STATE OF NORTH CAROLINA
DEPARTMENT OF TRANSPORTATION

Addendum No. 1

RE: Contract ID C203160

NS/NCRR Mainline Bowers To Lake Railroad Roadbed (MP 309.8 To MP 314.0)

PROJECT REFERENCE NO. SHEET NO.
C-4901A CP-02

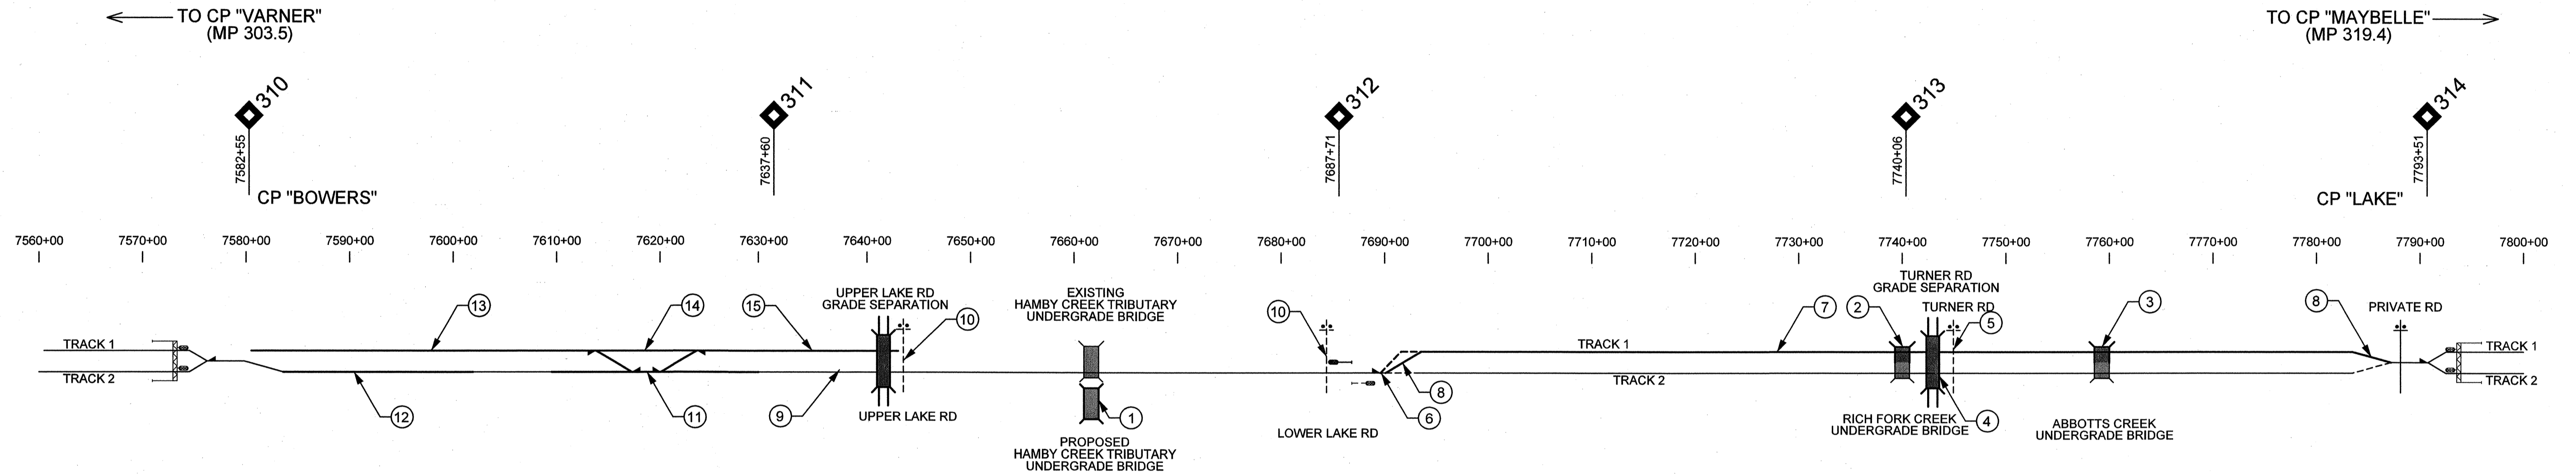
CP-02	Revised to show Private grade crossing left in place.
CP-03	Updated construction phasing so that construction of the trk 2 side of the Rich Fork Creek and Abbotts Creek Bridges is Step 1. Revised to show Private grade crossing left in place.
CP-04	Updated the construction phasing so that track removal in Step 1 includes Sta. 7759+79 to 7775+81. Revised to show Private grade crossing left in place.
CP-05	Revised to show private grade crossing left in place.
X-16 thru X-30, X-36 thru X-47, X-70, X-71, X-77 thru X-82, X-85, X-86, X-94, X-97, X-98	Revised per typical section changes
